Online Comment

Application H11-1264-25
Location Land to the side & rear of 90 Bridge Road Long Sutton Spalding PE12 9EF
Proposal Re-location of 24 Hour vehicle recovery, haulage, parking & storage

Name Ruben Lopez Catalan
Address Lincolnshire County Council, County Offices, Newland, Lincoln LN1 1YL
LN1 1YL

Date Submitted 19-01-26
For/Against Comments

SITE PLAN - EXISTING 1:500

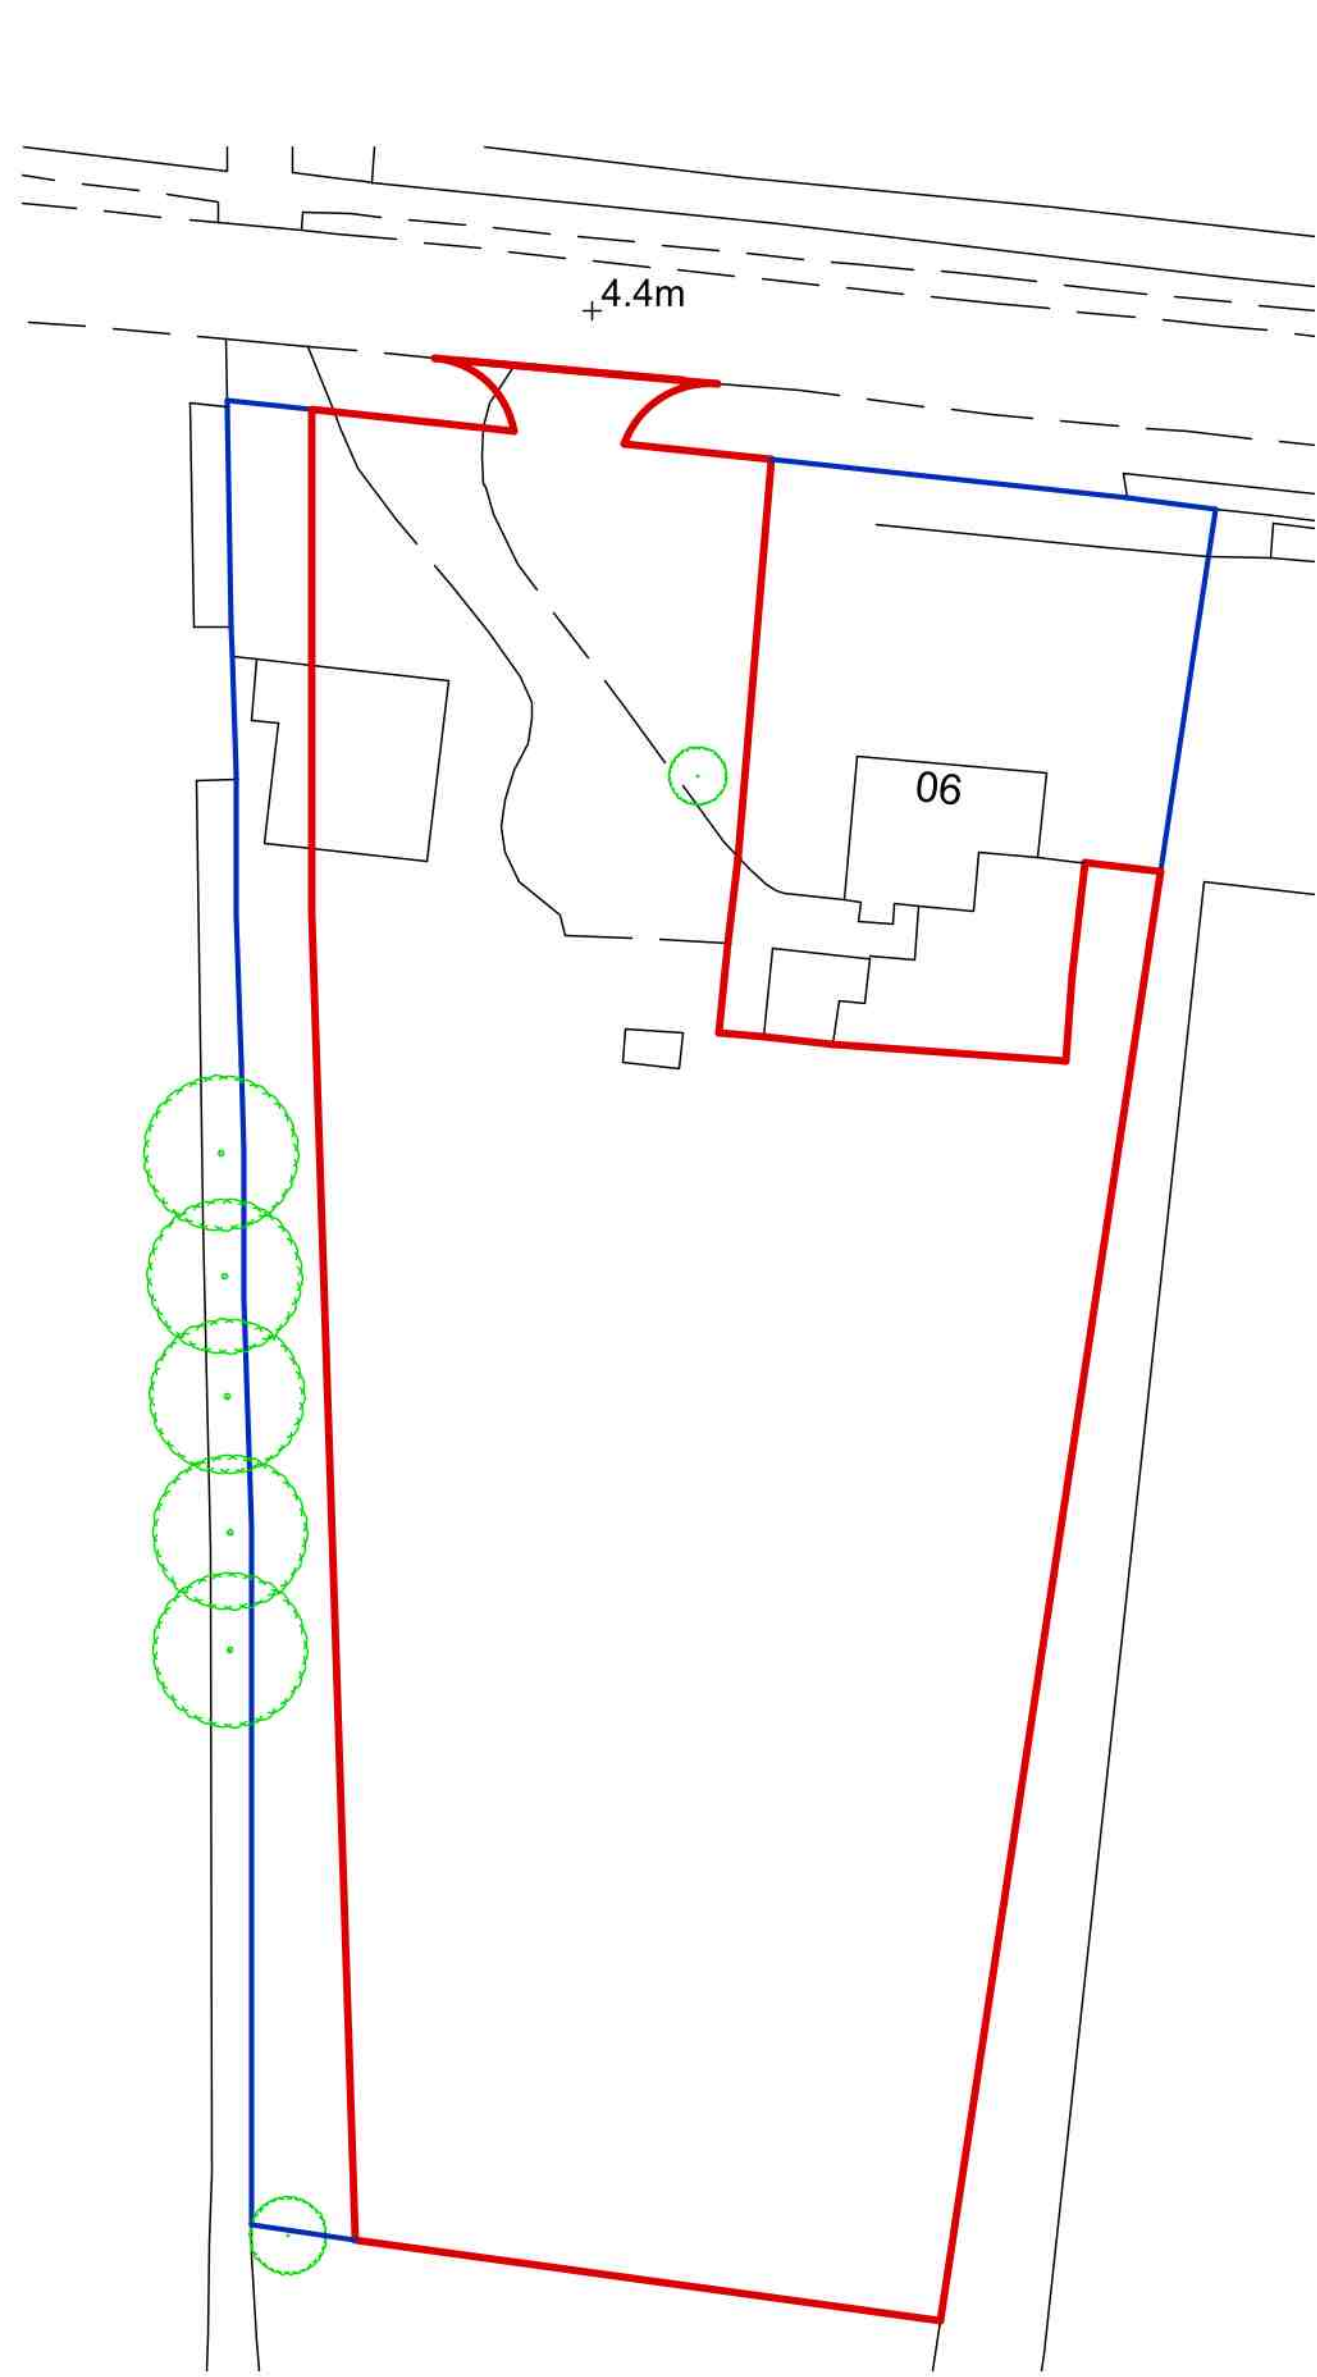
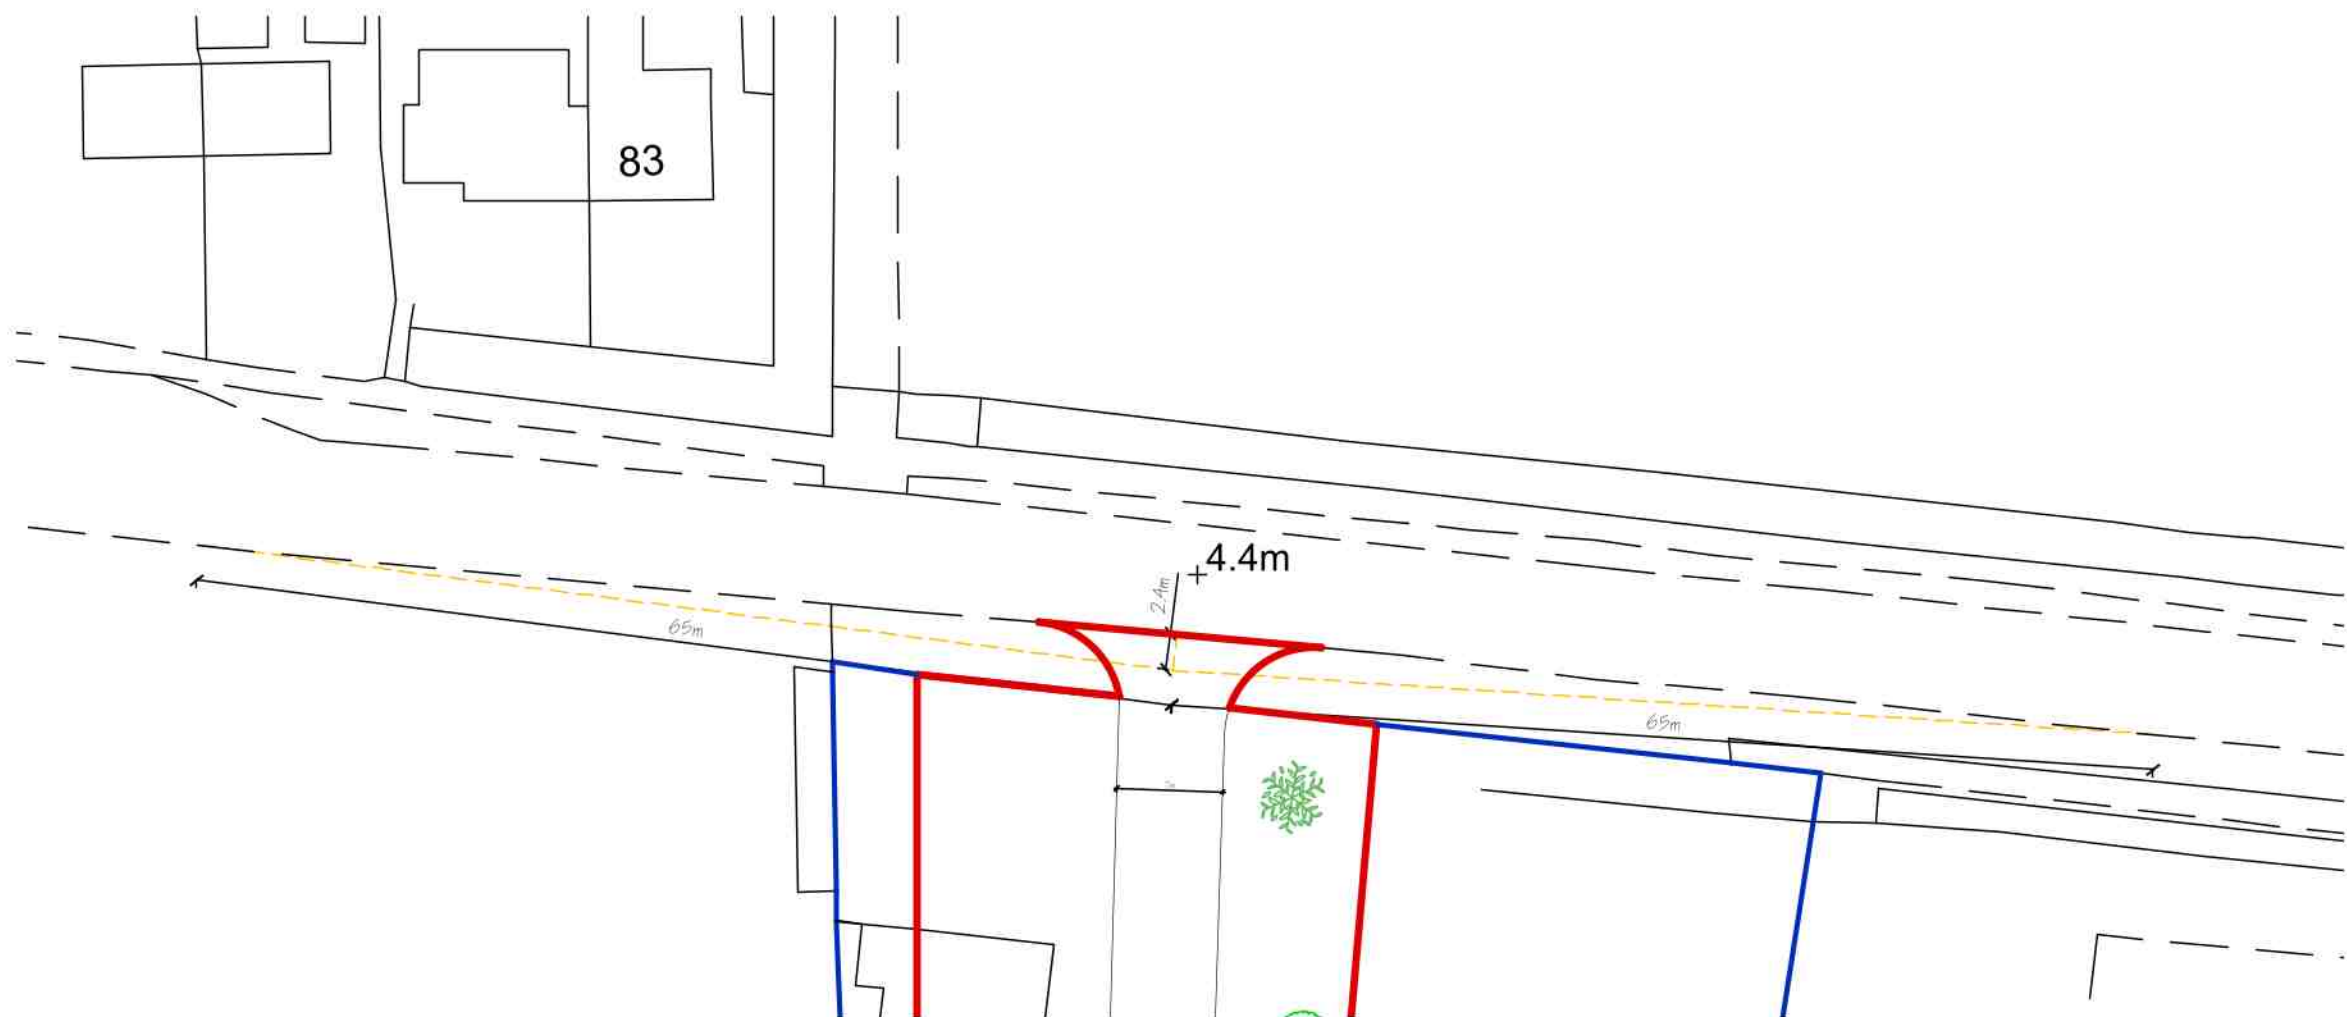
Historic mapping information - OS Map 1888-1913 in the LCC Heritage Explorer confirms the presence of an existing brickwork agricultural building, possibly a barn or part of an extant farmstead.

The existing brickwork building to be retained is considered a non-designated heritage asset (NDHA) due to its distinctive construction. Farmsteads from 1880-1940 are referenced in Historic England's Agricultural Buildings: Listing Selection Guide (2011) and the Greater Lincolnshire Farmsteads Project (2015), reflecting their architectural distinctiveness and heritage value. These buildings also feature in the Building the Evidence Base for Historic Farmsteads in Lincolnshire project, which mapped historic farmsteads predating the early 1900s Ordnance Survey mapping.

The building is within the red boundary and, although it is proposed to be fenced and excluded from the development, it remains within the works area and is therefore subject to potential direct and indirect (setting) impacts on its original fabric.

I recommend that, if permission is granted, a condition be attached requiring a mitigation strategy to effectively address this site.

This will comprise a programme of pre-development mitigation work including, but not limited to, a Level 3 historic building recording of the brickwork building, in accordance with Historic England's document Understanding Historic Buildings: A Guide to Good Recording Practice (2016). In addition, an AMP (Archaeological Management Plan) is required to ensure the protection of the building during the works and its appropriate fencing.

This will enable the brickwork building to be recorded prior to any development works taking place.
